Heckington Fen Solar Park

EN010123

Statement of Common Ground with Environment Agency

November 2023

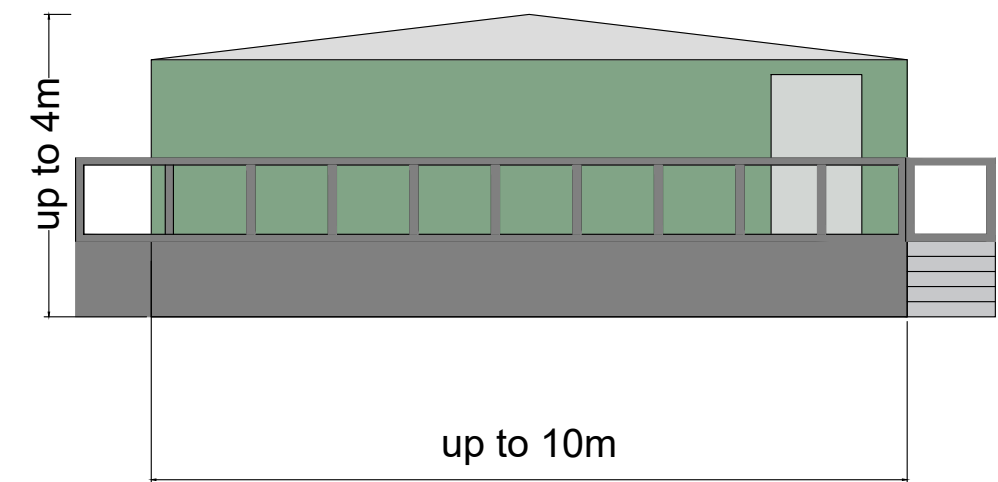
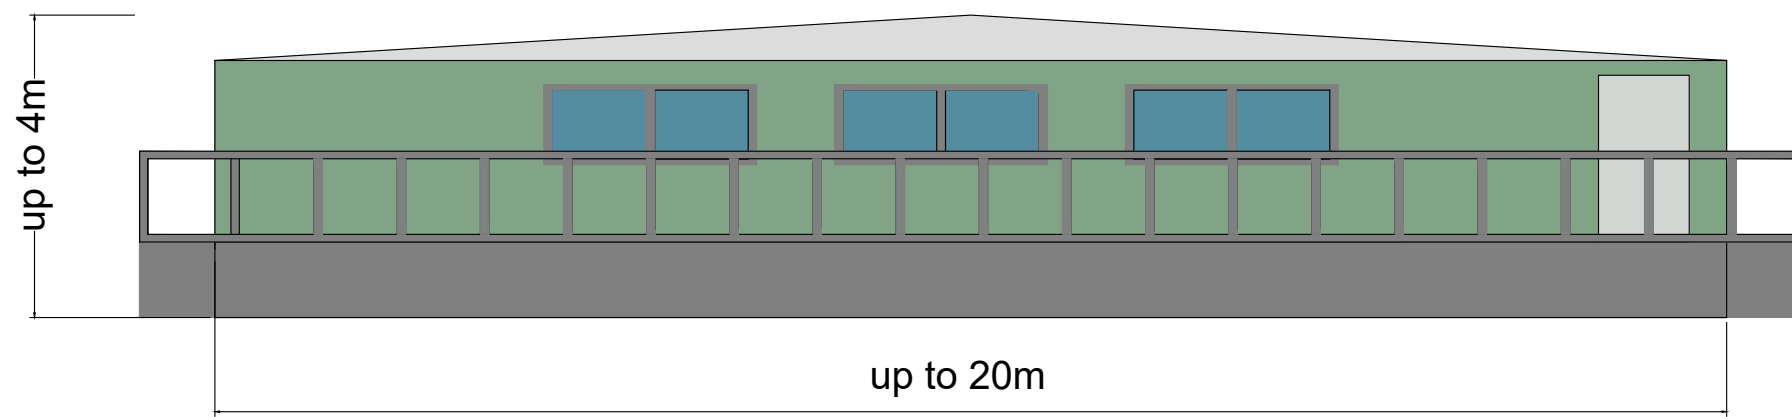
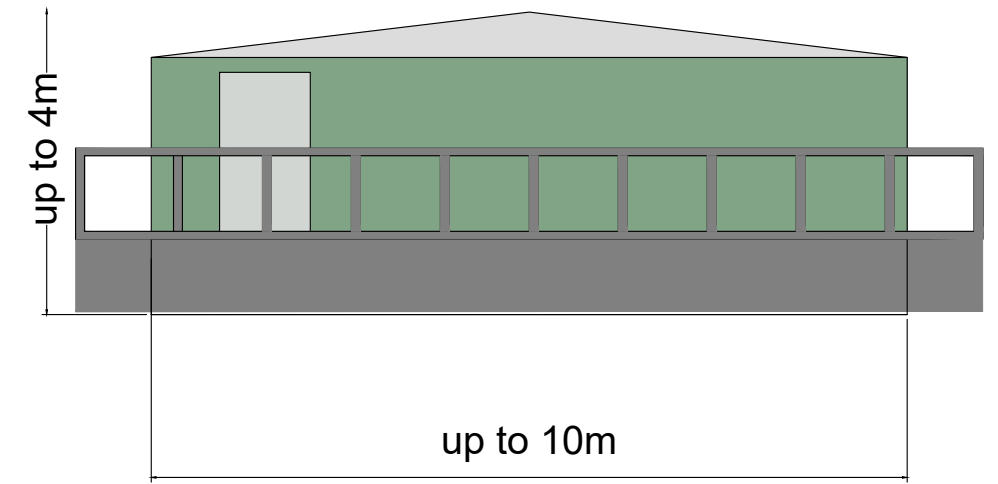
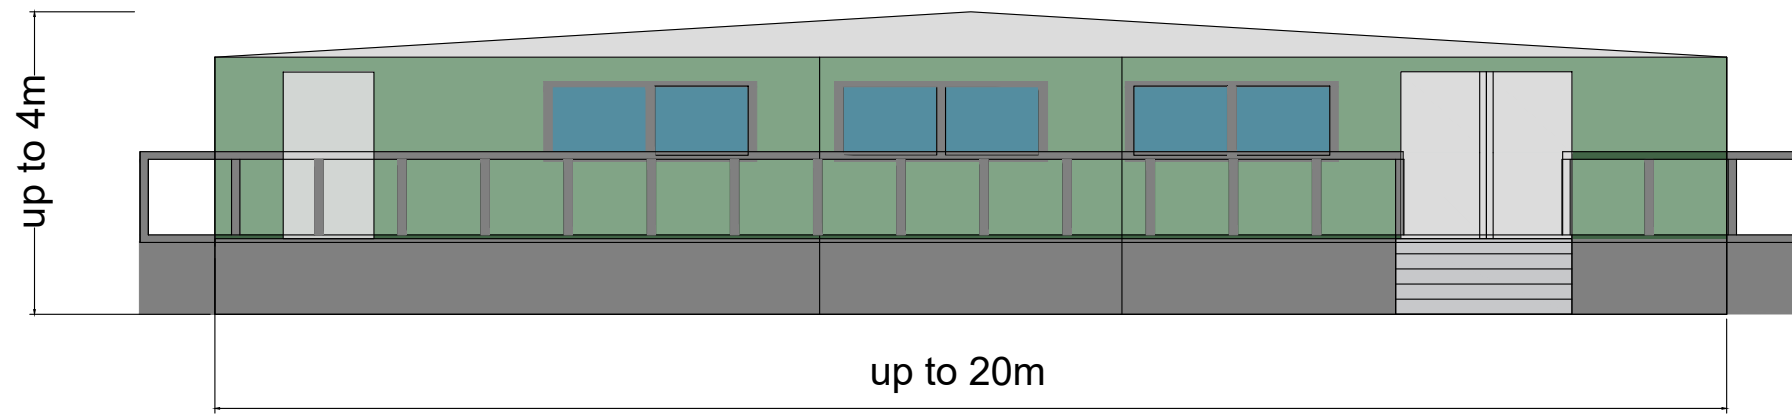
Reference and Status	Topic	EA’s Position	Applicant’s Position
1. Assessment of effects (including survey areas, baseline data and methodology) relating to Flood Risk and Drainage			
1.1. <u>Under Discussion Agreed</u>	Environmental Statement Chapter 9 – Hydrology, Hydrogeology, Flood Risk and Drainage Chapter 9 alongside Appendix 9.1: Flood Risk Assessment, Parts 1 and	The EA has reviewed the FRA from a fluvial perspective only (other sources of flooding such as groundwater, drainage systems, reservoirs, canals and ordinary watercourses fall under the remit of other flood risk	The Applicant can confirm the finished floor level of the control room at the energy park site will be at or above 2.25m AOD. <u>Figure 4.21 and Figure 4.22 are resubmitted to confirm this.</u>
